**Recommendation Report for Listed Building Consent for Alterations, Extension or Demolition of a
Listed Building**

REF NO: A/145/18/L

LOCATION: 200 Arundel Road
Angmering
BN16 4ES

PROPOSAL: Listed building consent for a single storey rear extension.

PLAN & ELEVATIONS PROPOSED

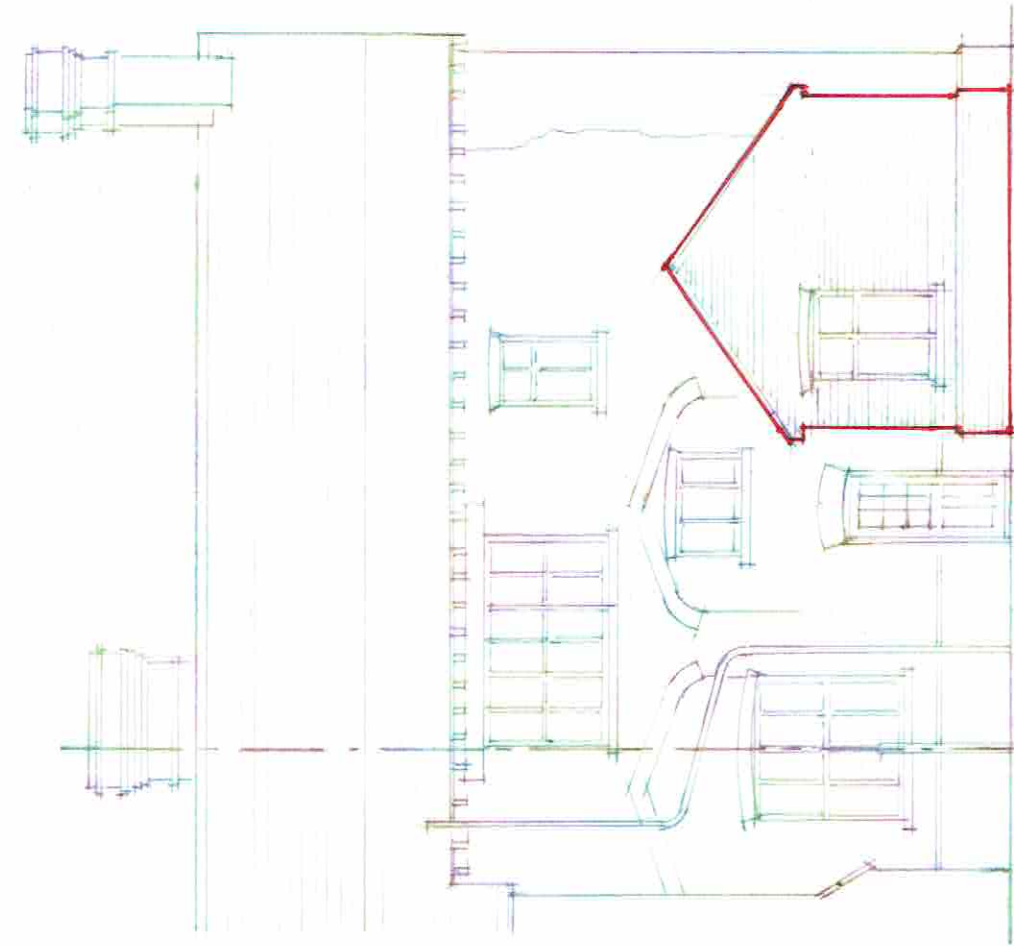
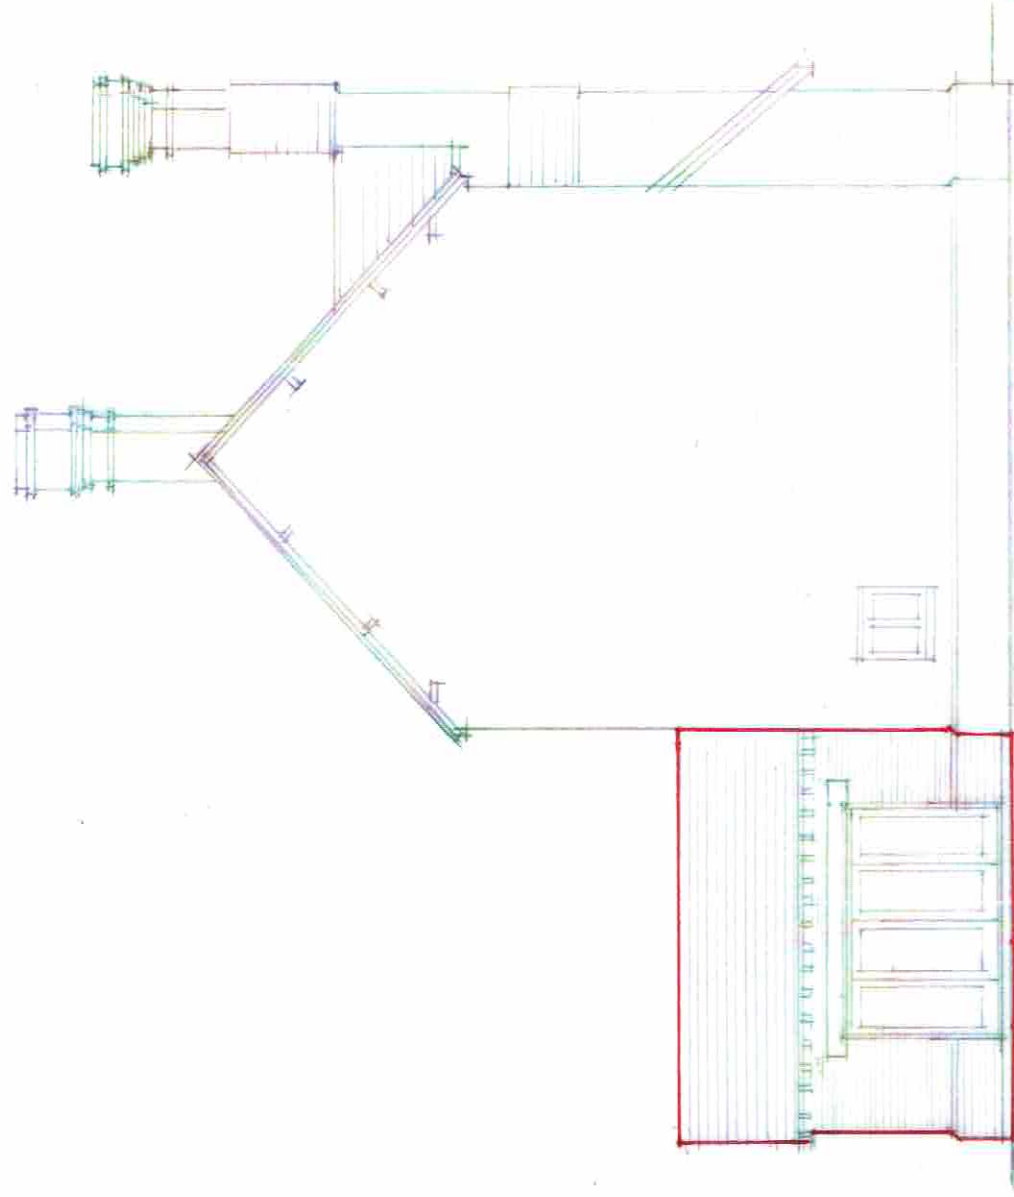
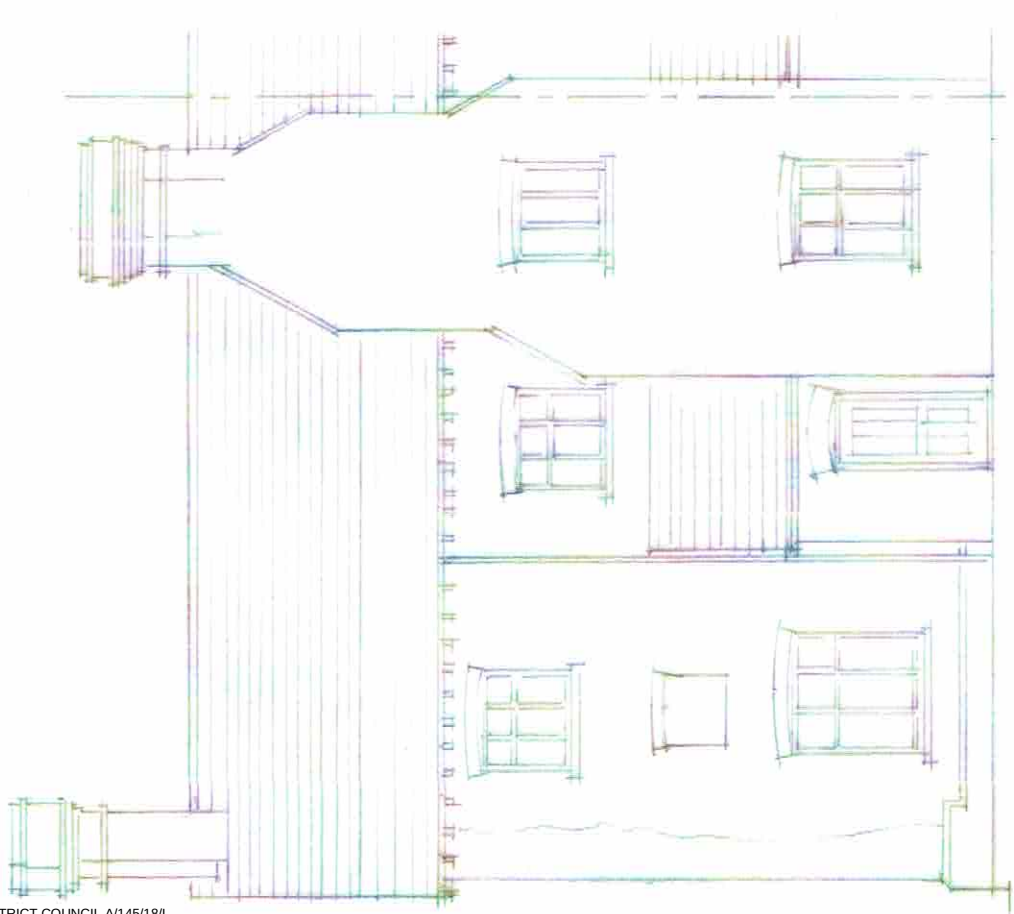
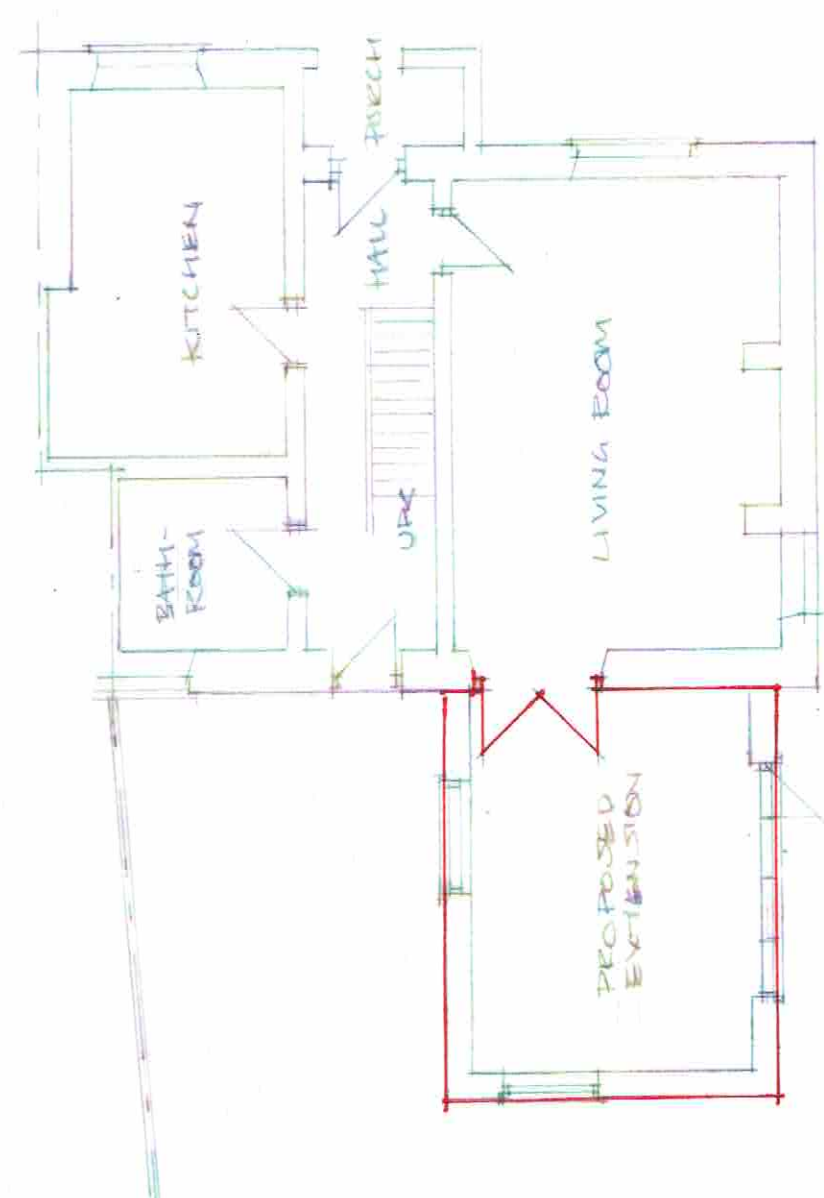
The proposal is to construct a rear, single storey extension to provide an additional room. The new addition is to be directly attached to the principal building, with a tiled gable roof, and three openings. All materials are proposed to reflect those on the host building. Such an approach is supported, subject to the provision of samples/details of the materials, along with details of the proposed brick bond to be

The new extension is stepped back from the building's side wall and therefore not visible from the front of the building. This will retain a sense of the principal building's form, whilst ensuring that the extension is subservient. This concept could potentially be enhanced through locating the bi-folding doors on the eastern elevation as this would leave the western elevation with only the older window which serves the living room. A balanced judgement will need to be taken with regard to this element of the proposal.

The proposal requires that a new doorway is formed by breaking through a rear window opening. This will see minimal loss of original brickwork and therefore historic fabric. Such an approach is considered to be the least harmful way of providing a new opening. Details of the windows and doors will need to be provided for by way of condition in order to ensure that they reflect the character of the building.
